KIRKLEES METROPOLITAN COUNCIL INVESTMENT & REGENERATION SERVICE

DELEGATED DECISION TO DETERMINE PLANNING APPLICATIONS

Reference No:	2026/62/90274/W
Site Address:	17, Broomfield Road, Fixby, Huddersfield, HD2 2HQ
Description:	Erection of single storey rear extension and alterations
Recommending Officer:	Joshua Merriman

Officer Report – 2026/90274

SCALE: 1/500
DATE: JAN 2026
DRG. NR. BP 01

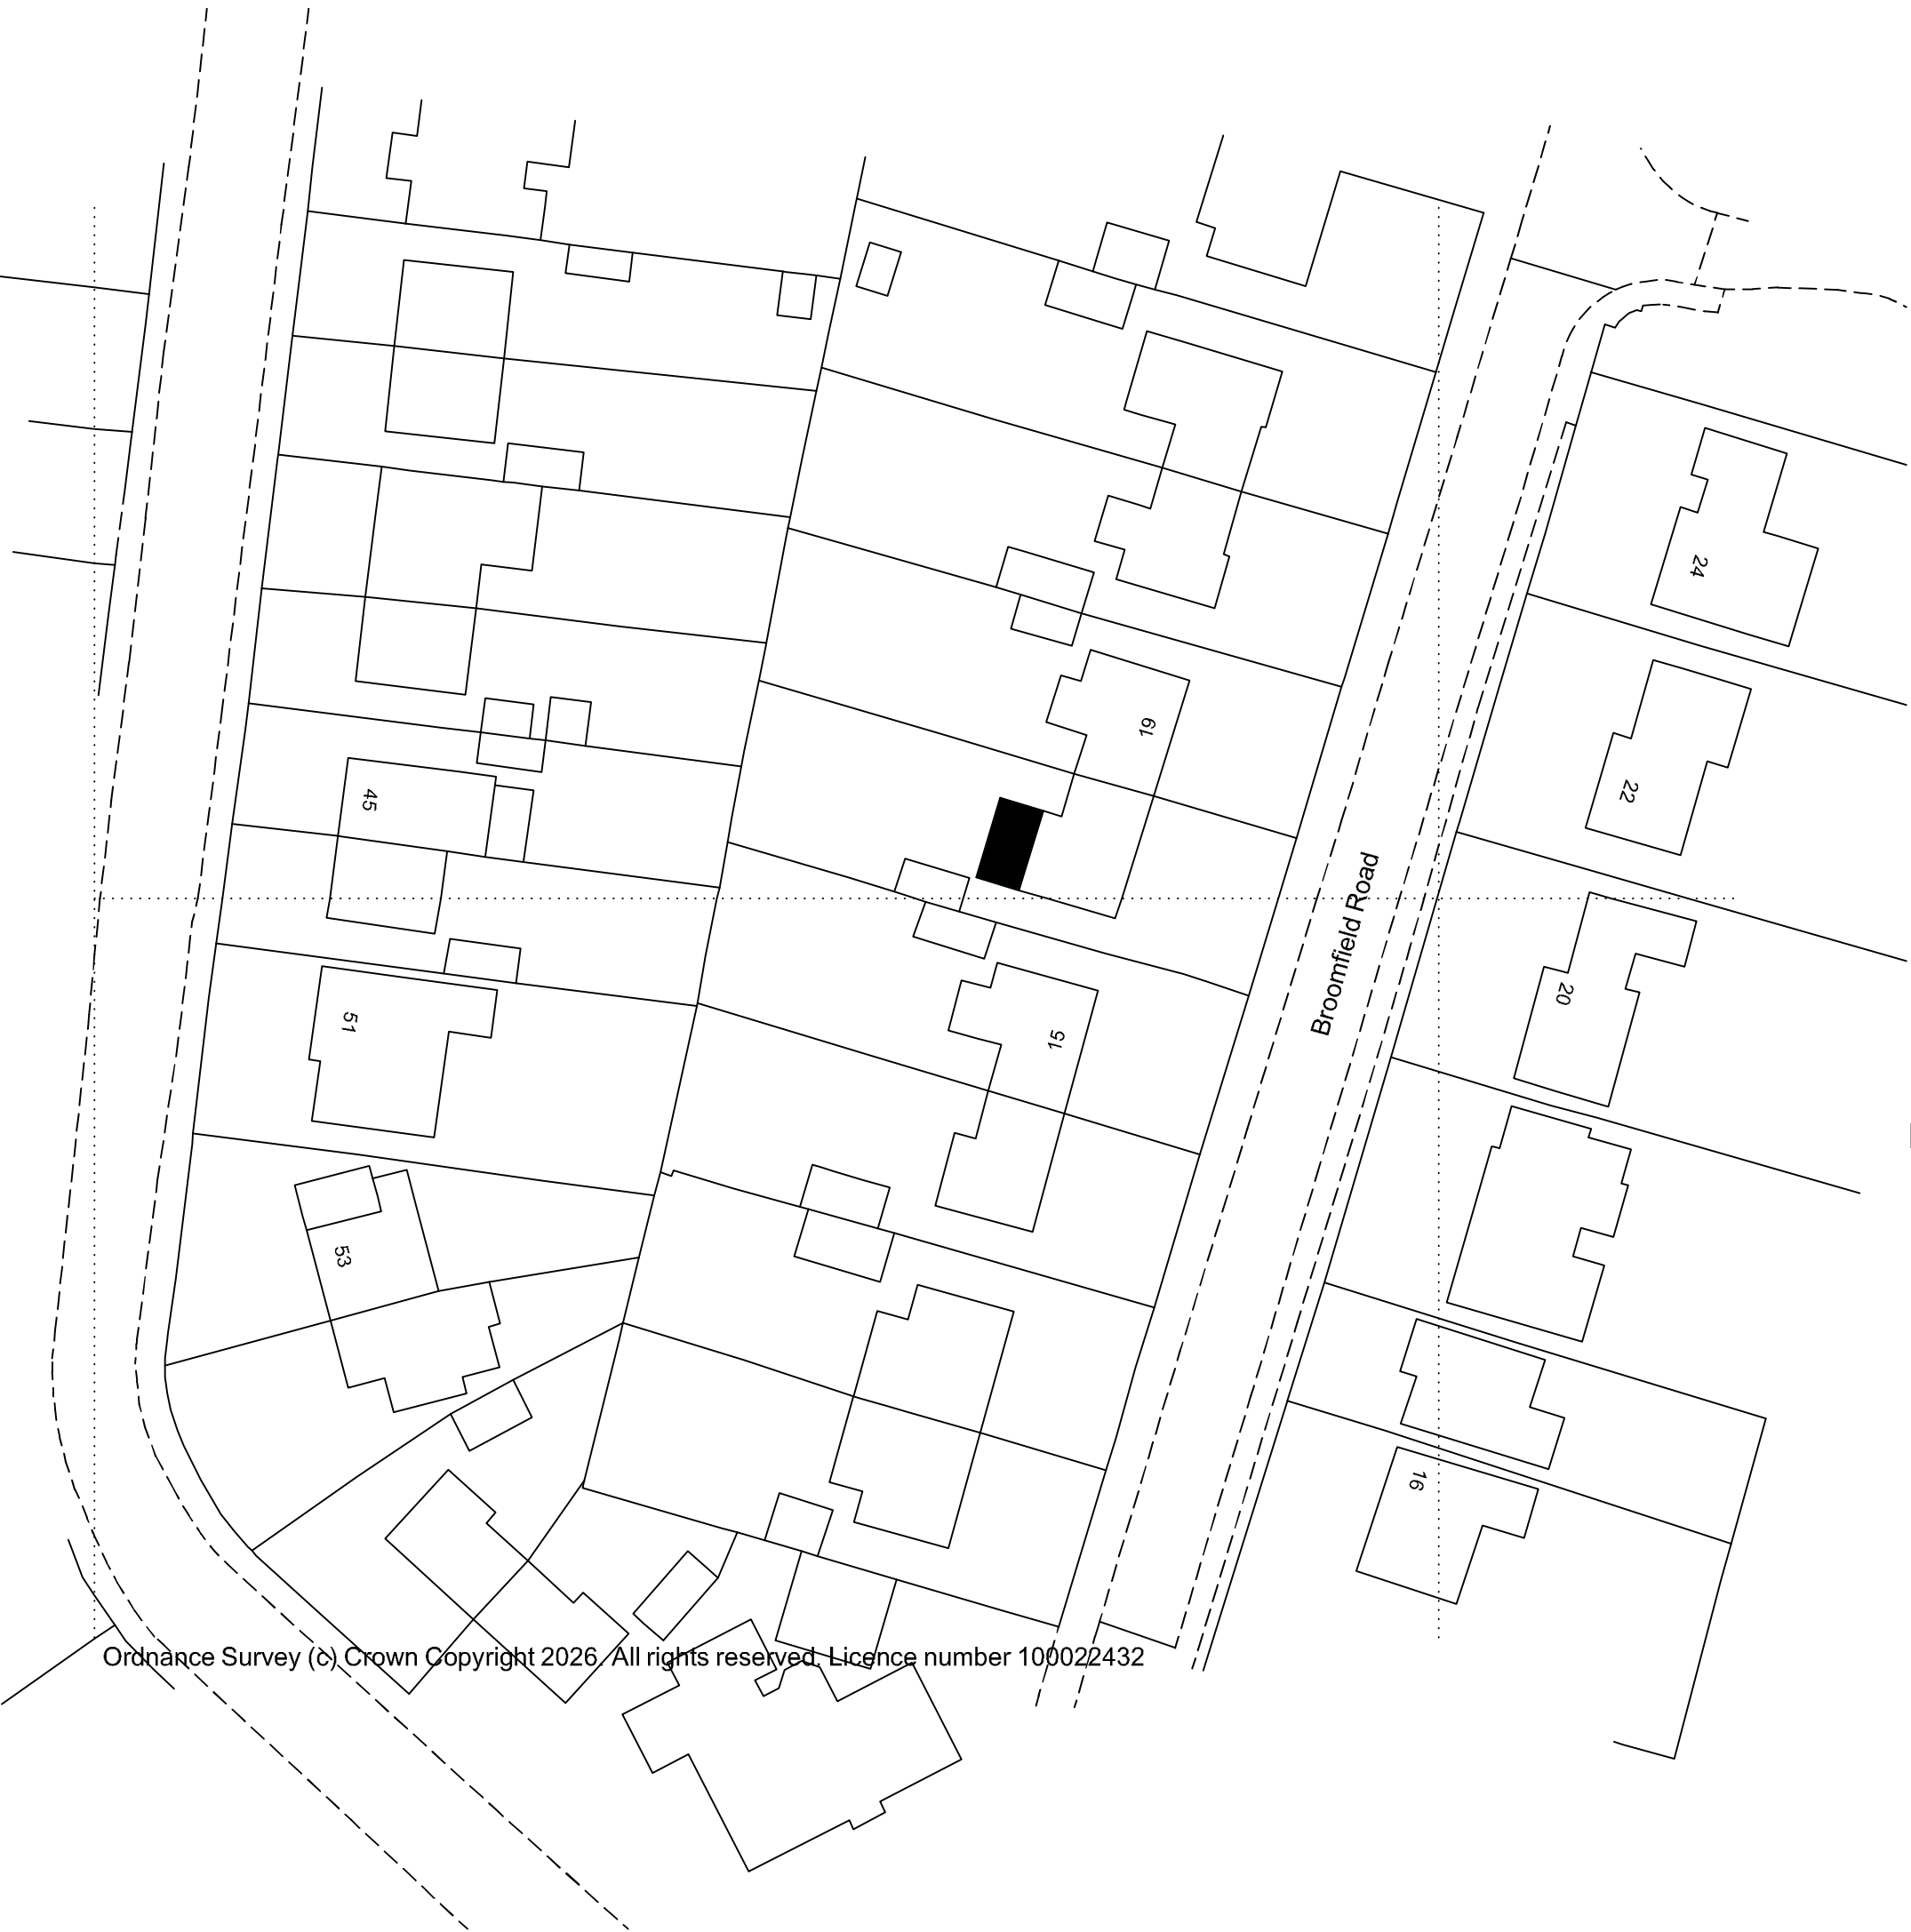
The proposal will ensure 50% of the total space around the property is retained, as well as external access to the rear garden.
